MECKLENBURG COUNTY  
Park and Recreation Department

MEMORANDUM

**RE:** Rezoning Petition #2024-051  
PID# 16926116

Dwg No.
**REZ
1.0**

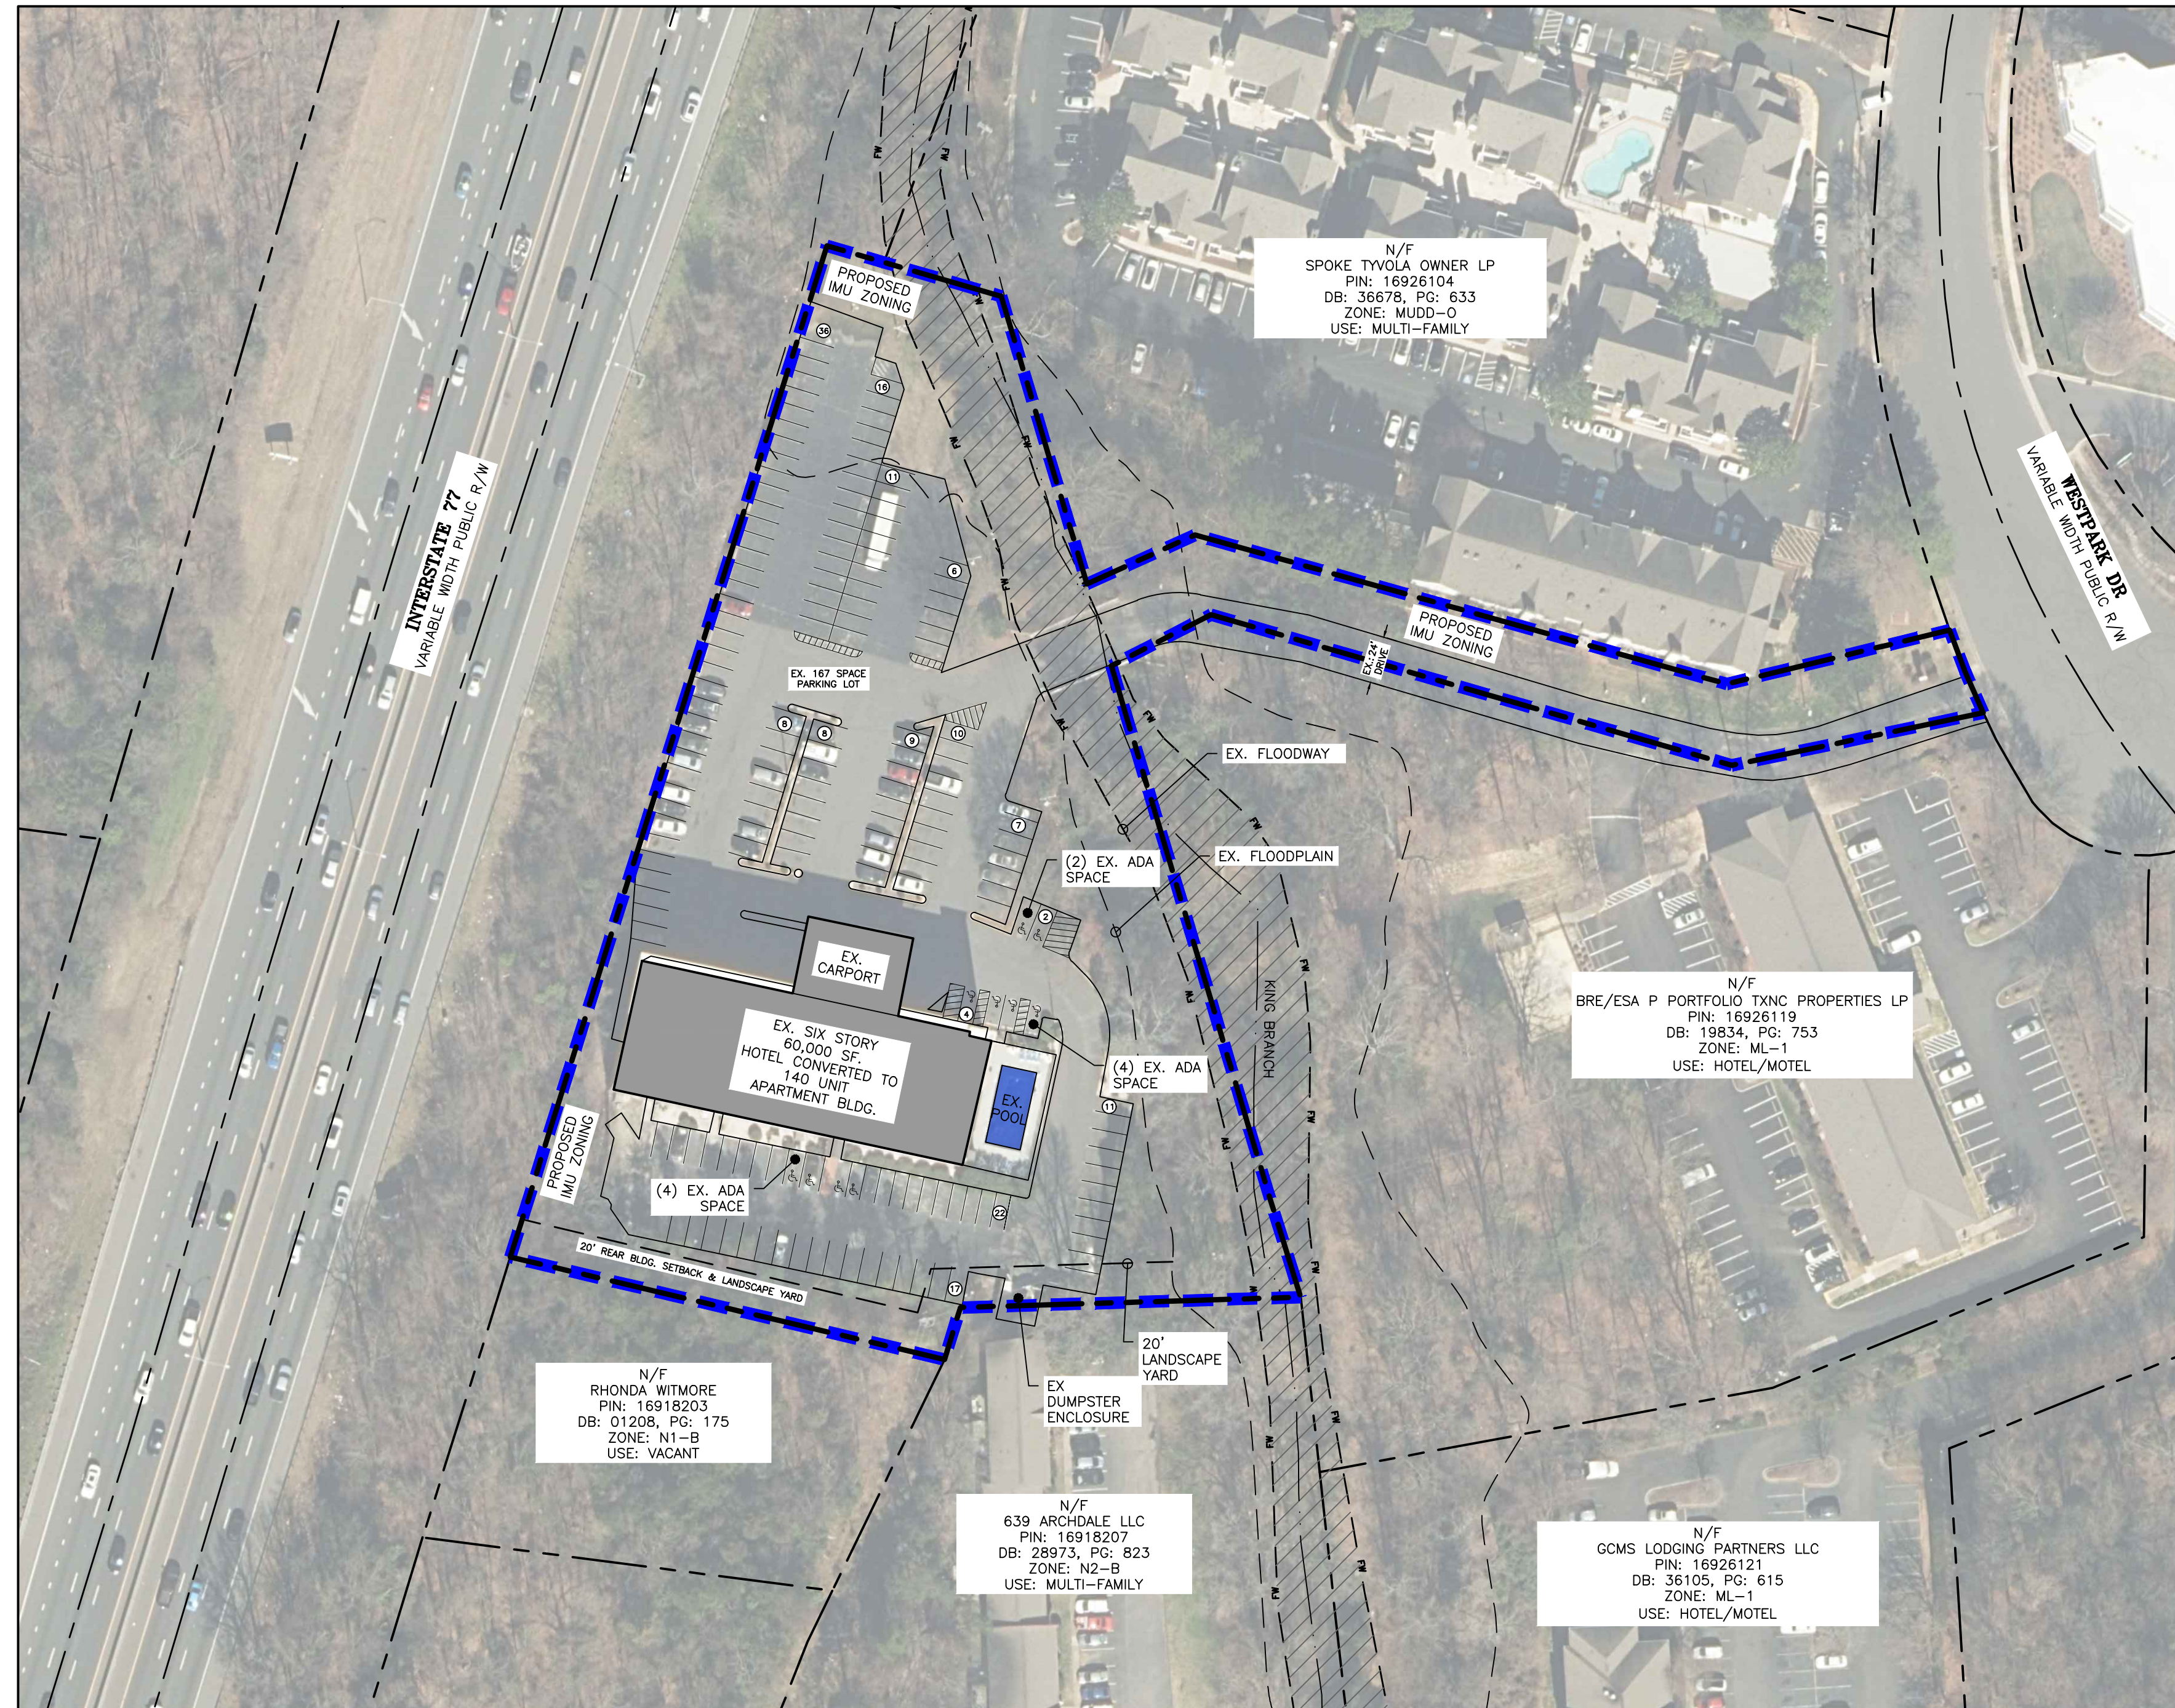
MCPR requests the petitioner dedicate and convey a greenway and storm water easement to Mecklenburg County which would include whichever is larger of the 100' SWIM Buffer or the FEMA Floodplain of Kings Branch for a future connection to Kings Branch Greenway Trail. The easement can overlap the tree save areas and the existing paved driveway; however, the easement area should exclude the existing paved parking areas. The easement should be conveyed prior to the first CO.
